Museum of Contemporary Art

Museum of Contemporary Art
Redevelopment Project
Preferred Project Report

April 2009

EAST ELEVATION

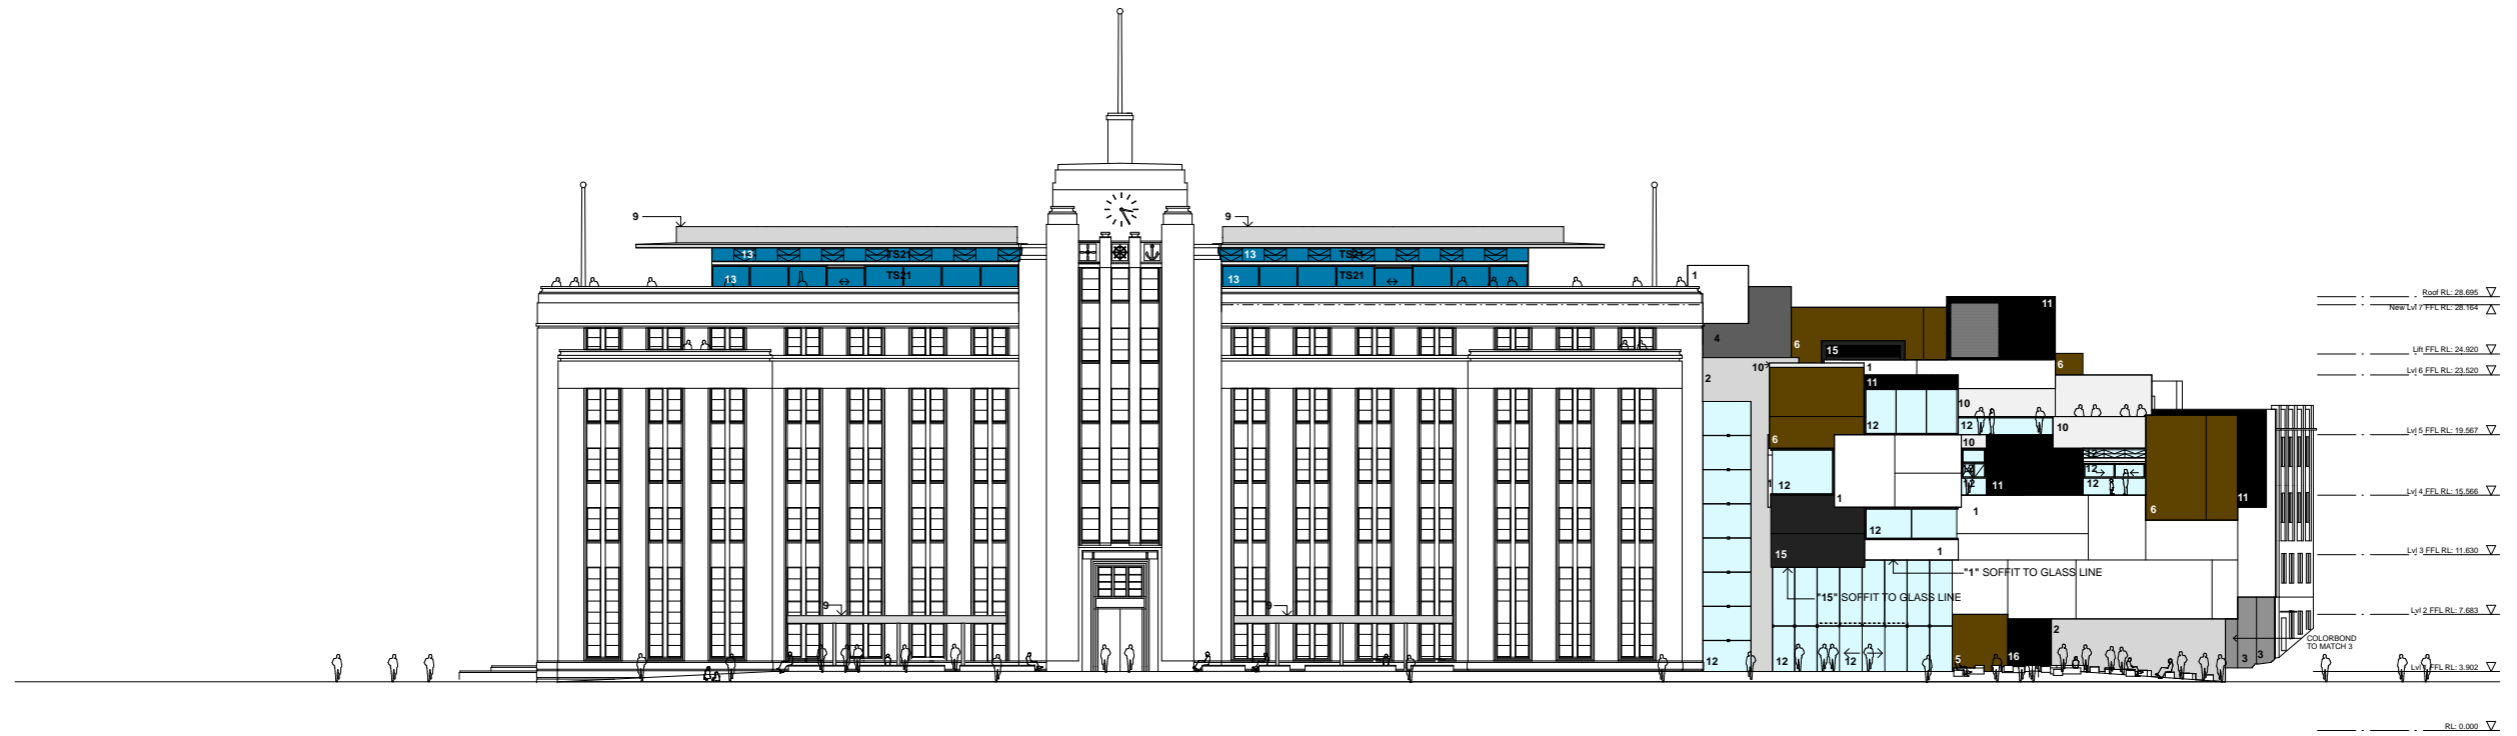
Scale and form not compatible with existing building, presents a heavy addition, which compromises the integrity of the existing building (including when viewed from Circular Quay). Solid materials and lack of set back from George St are of concern. Could support if reduced height and minimising the depth of roof structure as per discussion in meeting.

In response to the comments raised, we have developed the detailing of the roof edge to present a finer more feathered edge to lessen its visual weight and will adjust this edge to more sympathetically meet the existing fabric.

The connection to the existing building has been reconsidered in the light of the submissions and the roof at the George Street edge has been reduced from RL 32.877 to RL 32.156 to achieve alignment with the adjacent existing sandstone moulding. A detailed section is shown in Figure 9.

WEST ELEVATION

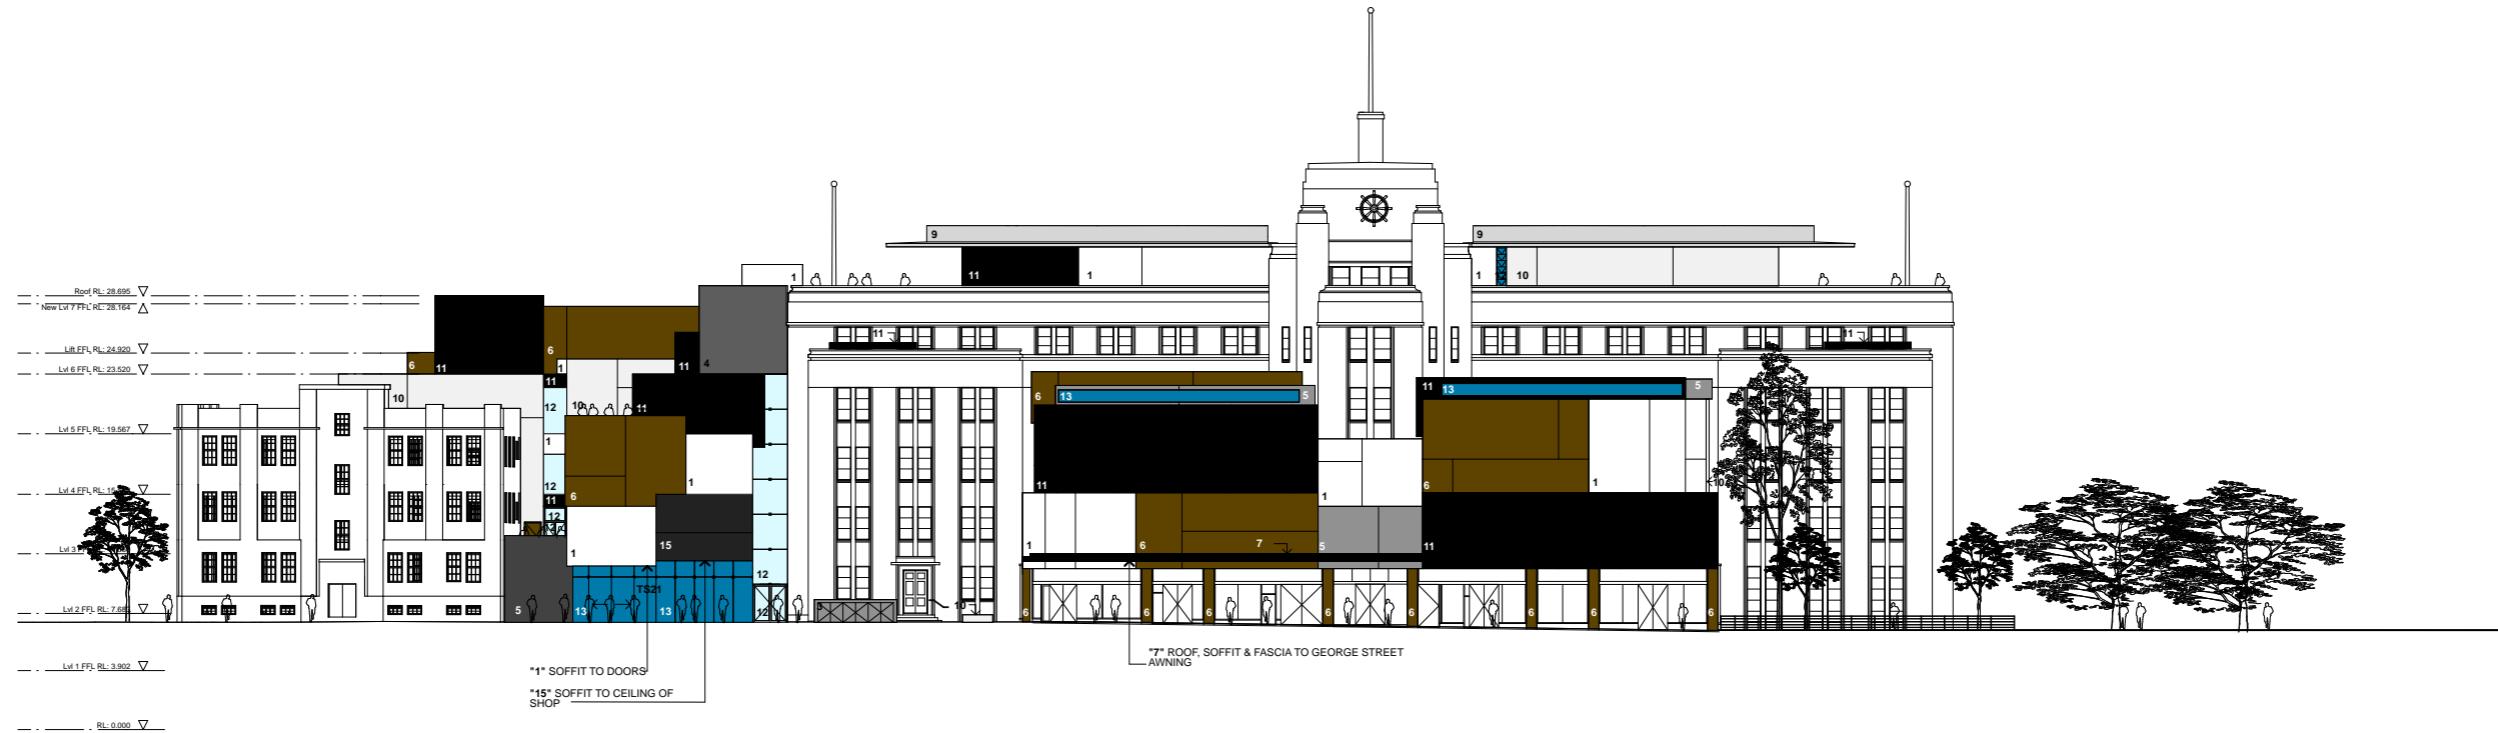
Raises concern with George Street elevation in regard to its impact on the existing building, both in terms of the visibility of existing windows and the architectural detailing and form of the (existing) building. The proposed addition will present as a solid four storey element, built to the George Street boundary of the site, and at over 40 metres in length will present as a very dominate element in the streetscape. You are requested to consider options to reduce the scale of the proposed addition to George Street, which should not be significantly above that which presently exists. Any loss of gallery floor space in this area could be replaced within other areas of building where it is proposed to provide for commercial tenants.

In response to the concerns raised, we have re-examined this elevation and modified the height as seen from the street and introduced more detail in the material palette to visually lessen the volume. We have reconsidered the Level 4 gallery and lowered the height of the middle section further revealing the strong central tower of the existing building and acting to further segment and lessen the scale of this elevation from the streetscape.

The northern 'block' of the Level 4 gallery has been reduced in height from RL 22.614 to RL 21.464 (reduction of 1.17 metres), the central 'block' has been reduced in height from RL 21.662 to RL 19.233 (reduction of 2.429 metres), and the southern 'block' has been reduced in height from RL 21.889 to RL 21.870 (reduction of 0.019 metres).
